Objection - Indefeasible photographic evidence on Boundary of Common Land and width of Bierley Marsh adjacent to St Luke’s Hall and through its length.

Whilst information has previously been submitted, there still appears to be differing views on the boundary of Bierley Marsh and Common Land (CL222). At the risk of repeating I restate legal advice on this matter and note that Kirkees Highways Registry have confirmed that proposed road works encroach on Common Land by up to 2.5m.

HM Land Registry Current title plan

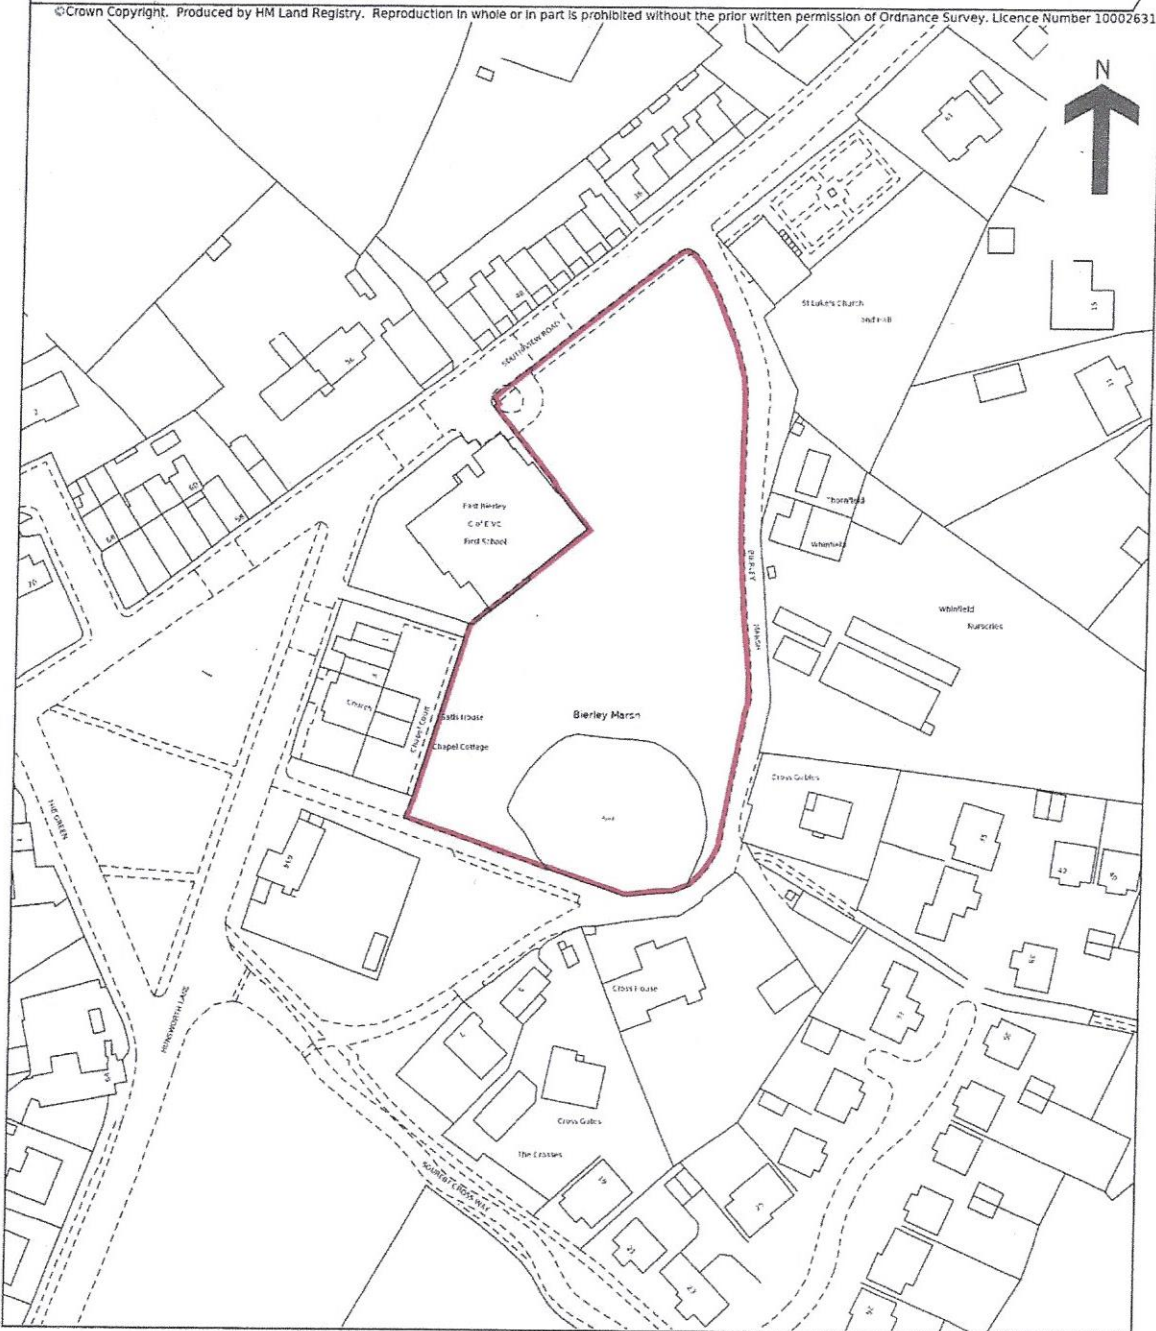
I object to further loss of Common Land. As indefeasible evidence I attach further photos identifying the legal position of the Common Land boundary.

The Land registry title plan WYK813938, above, shows a fairly regular contour of Bierley Marsh
